Application No: FG/34/21/HH
Site Address: 50 Ocean Drive Ferring BN12 5QP
Description of works: 1st floor side extensions, two storey front extension, side and rear extensions, installation of balcony to rear and 2 x front dormers including demolition of existing garage.

OWPC34859

REAR (w)

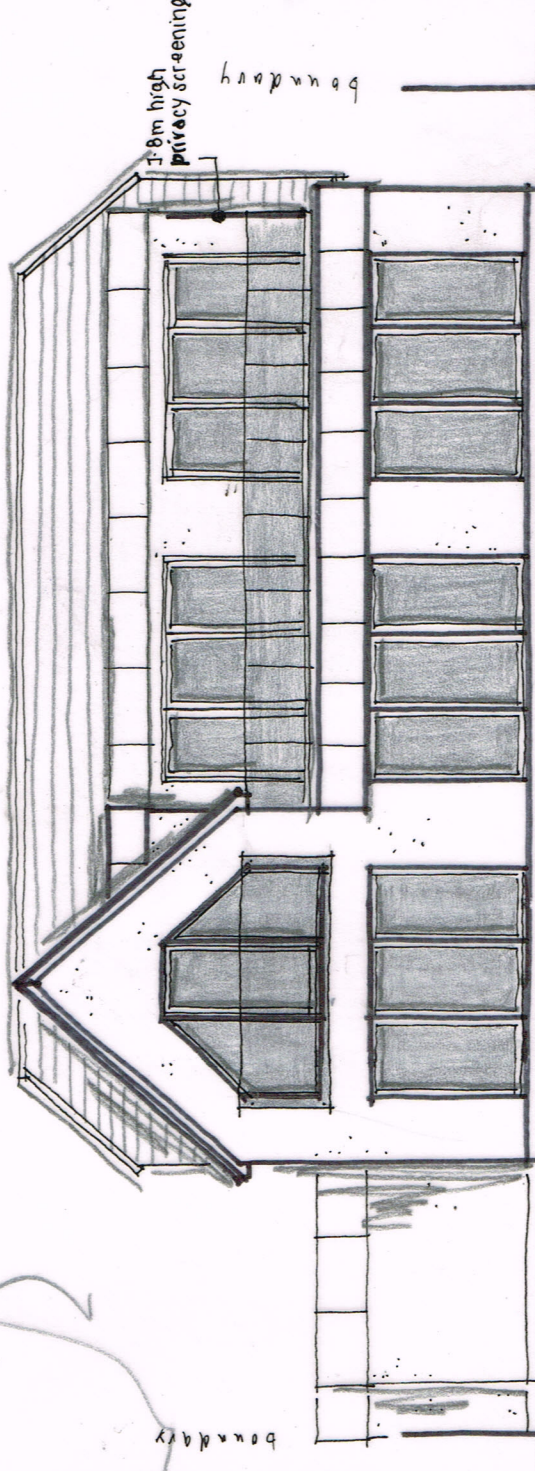
I live in a relatively small modest bungalow fairly close to where these alterations are planned and it seems to me that the scale and size of these proposals will mean this property will have a dominating and overbearing effect on several other properties in the immediate area including mine. I am also very concerned as to the possible loss of privacy in that my small garden may well be overlooked from the proposed large balcony on the west elevation, therefore depriving me of my personal privacy.
